### **Crystal Park Site 184, CP-17-005**

**Please accept the following comments from El Paso County Public Health regarding the project referenced above:**

- **Crystal Park Site 184, 5020 High Ridge View, is a residential development site that will be served water by an individual private well and wastewater through an on-site wastewater treatment system (OWTS).**

SITE PLAN AND TOPOGRAPHIC SURVEY

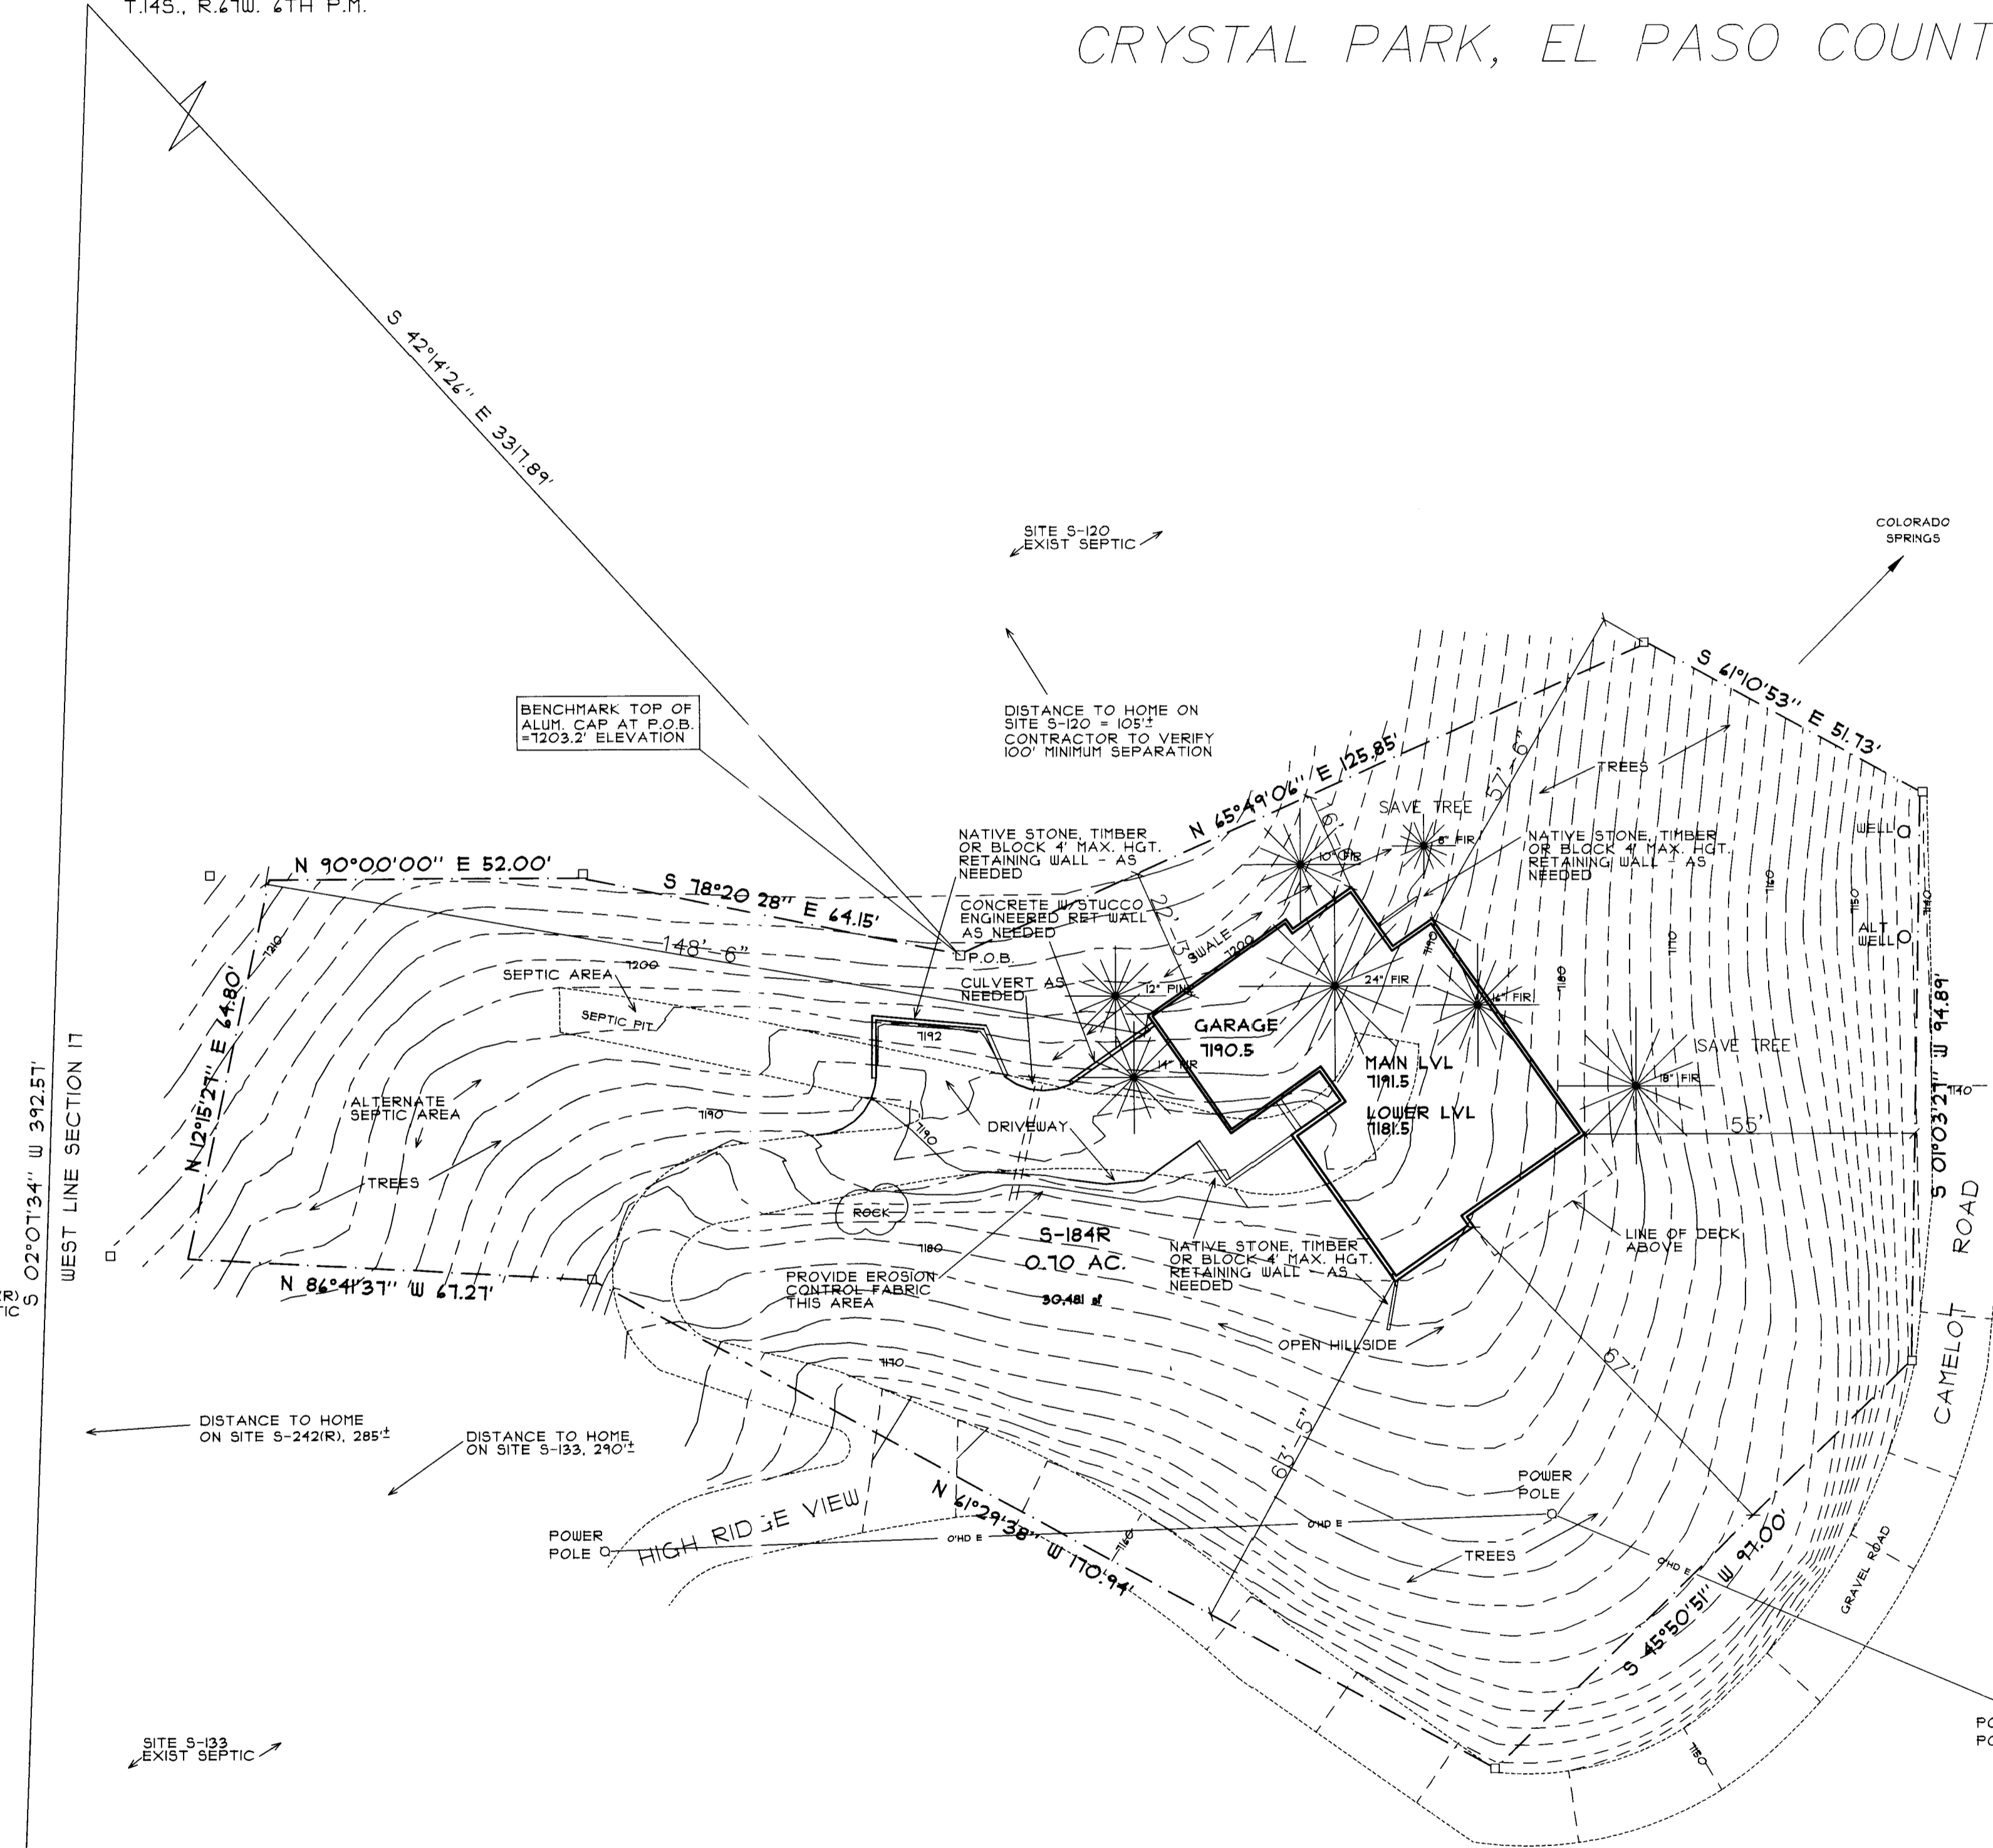
- **The site development plan indicates an area for a “septic pit” and an area for an alternate septic site. The OWTS must meet all current El Paso County Public Health OWTS Regulations including OWTS permit approval. Please be aware that a vertical soil treatment area (STA) or “pit” is the last type of STA to be considered for approval. The results of the soil test in these areas will determine the types of STA’s to be considered for approval.**

- **The OWTS areas must be 100’ minimum from any well, internal or external, and also must be protected from all house construction and site development activities. Well locations were not shown on the Site Plan; therefore, be aware of the 100’ setback requirement.**
